## PLANNING CONSULTATION RESPONSE

<b>Application No</b>	2026/0091
<b>Proposal</b>	Alterations to the existing garage to form an annexe.
<b>Address</b>	Coxbench House, 60 Doncaster Road, Darfield, Barnsley, S73 9HX
<b>Date of Consultation Reply</b>	20/02/26
<b>Consultee</b>	Highways DC

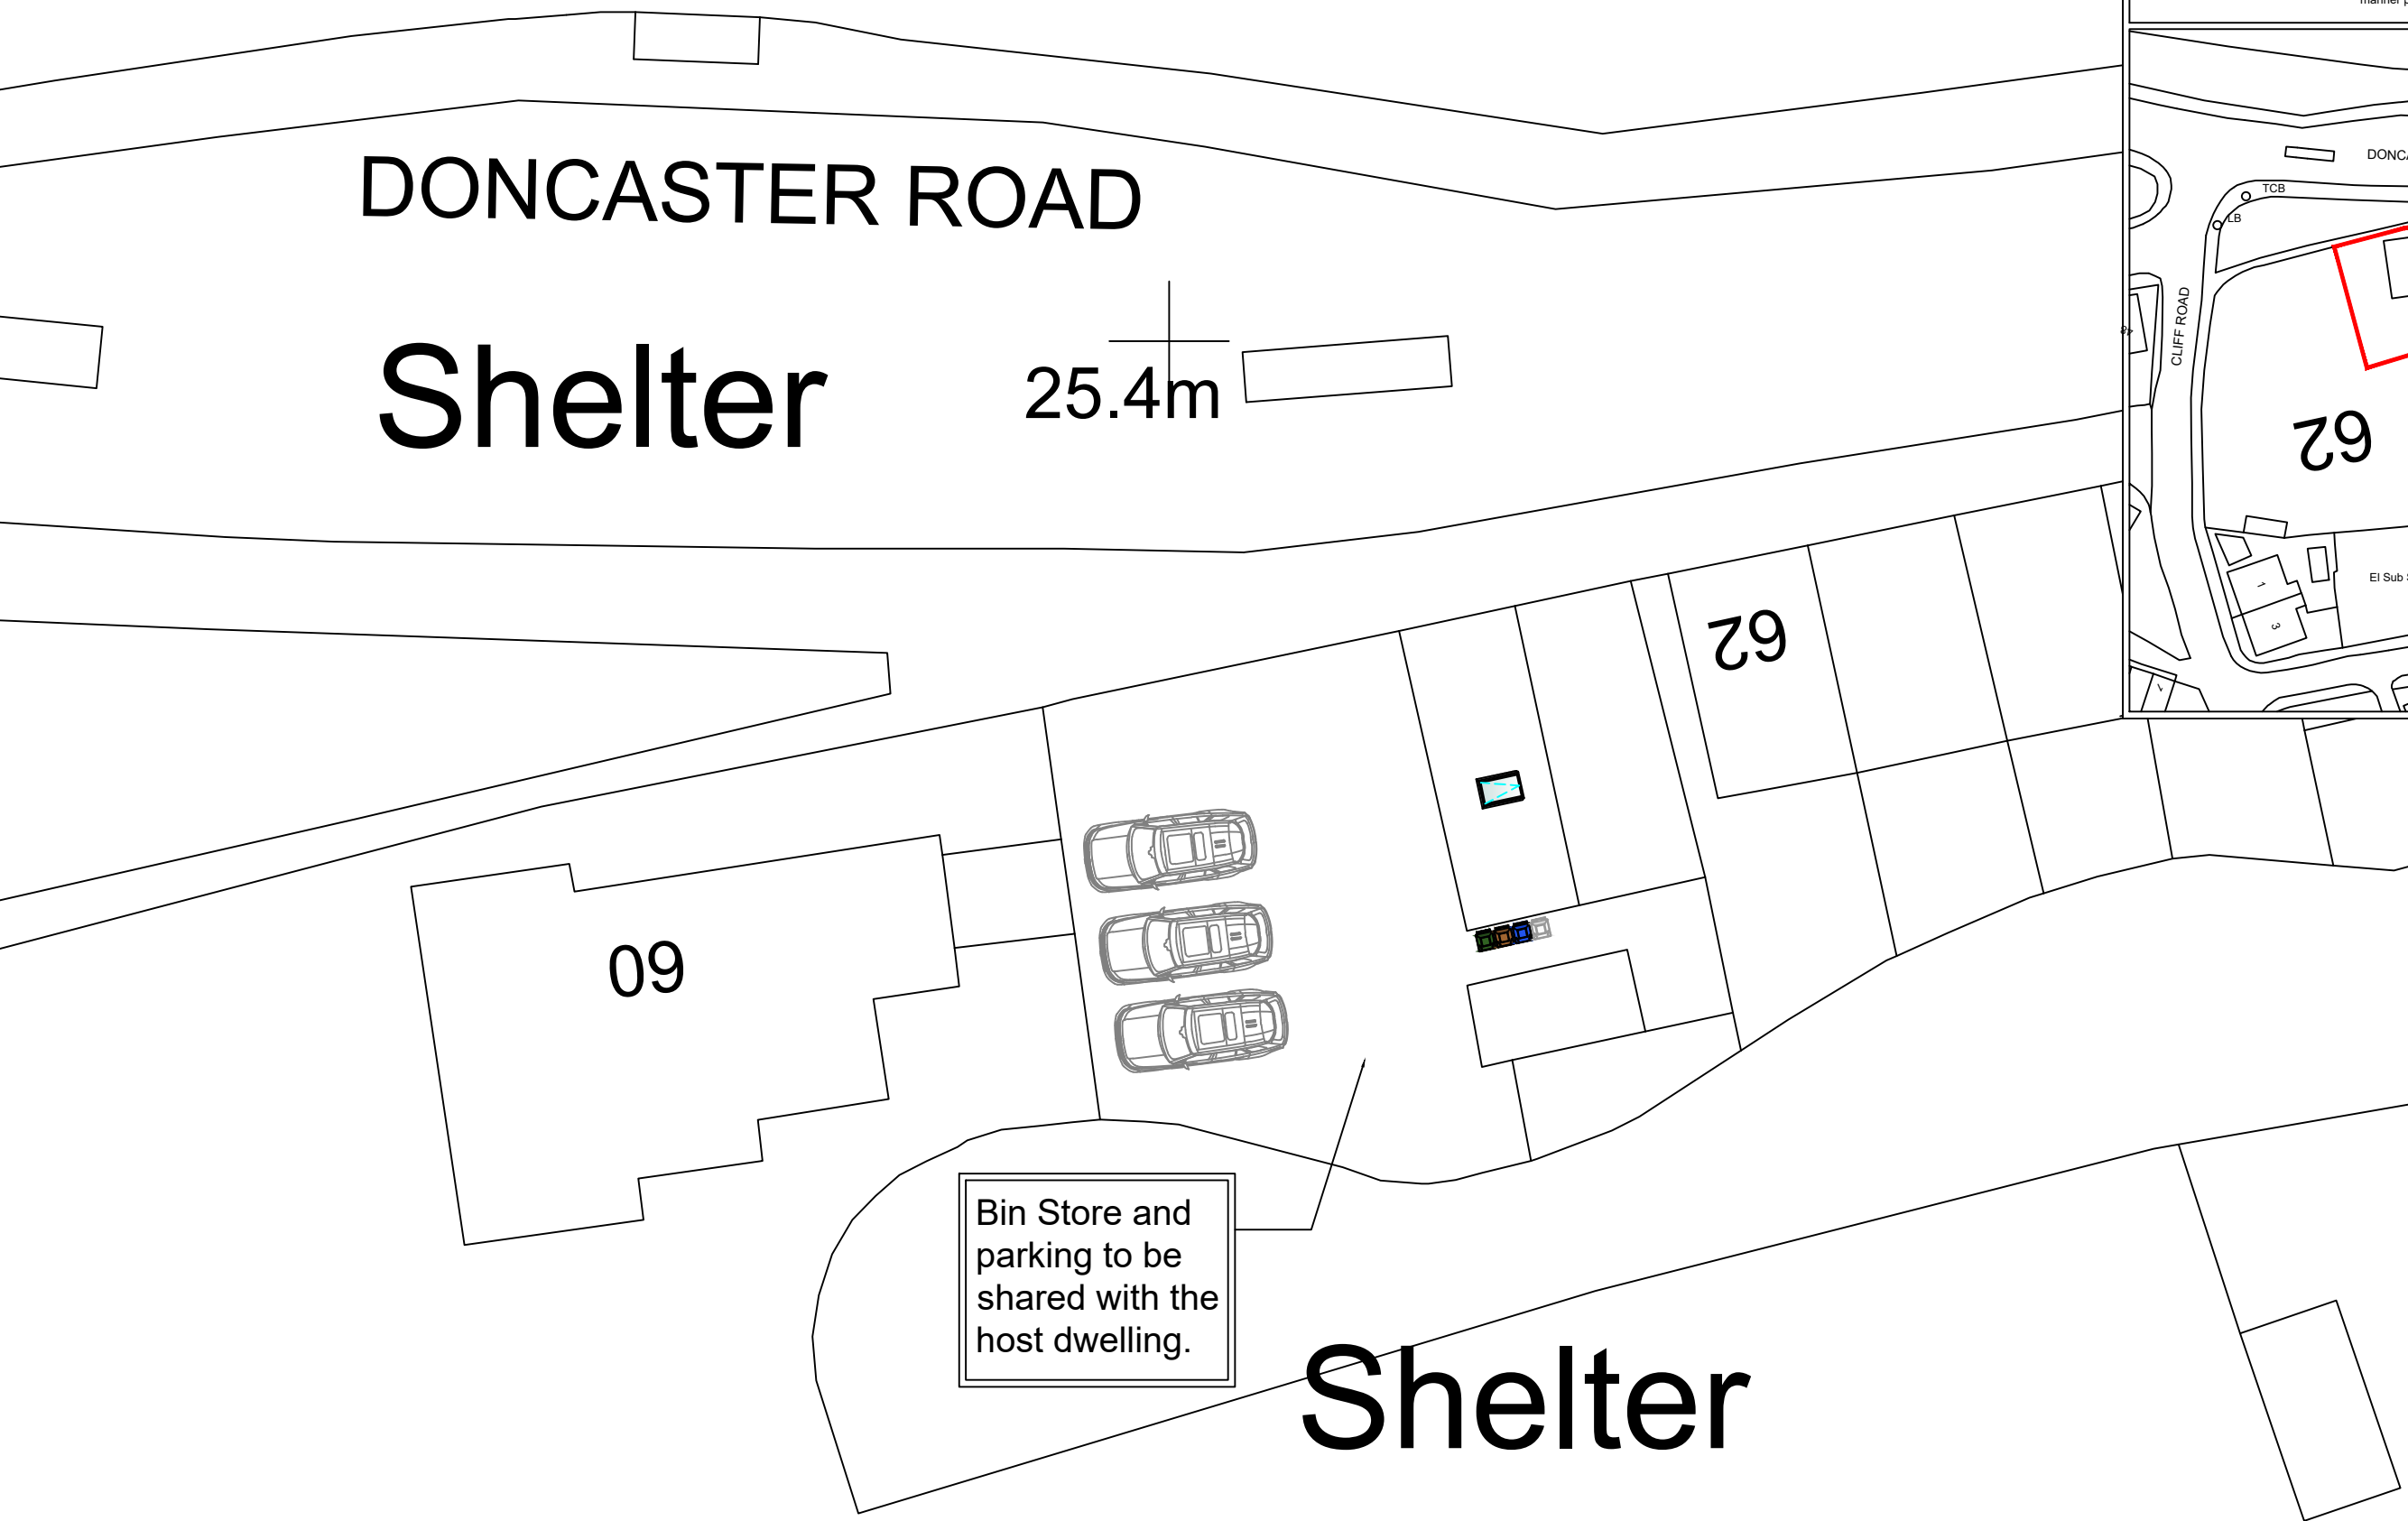
The proposal would convert the existing garage space into a single-bedroomed annexe. Off-street parking for three vehicles and a bin storage area are shown in drawing no.10/25/89.

As the driveway retains a width of over 11m, internal turning is achievable to allow a vehicle to enter and exit the A-classified Doncaster Road in a forward gear. Whilst the scheme is therefore acceptable as an annexe, HDC would require further detail of access width, refuse storage and collection, and off-street parking provision should there be a future intention to split the properties into two separate, privately-owner dwellings. The below condition should therefore be included in the decision notice.

Annexe: Notwithstanding the provisions of the Town and Country Planning (General Permitted Development (England) Order 2015 (or any Order revoking and/or re-enacting that Order), the annexe hereby permitted shall be retained as such and shall not be used for any purpose other than uses ancillary to the main dwelling Croxbench House, 60 Doncaster Road without the grant of further specific planning permission from the LPA.
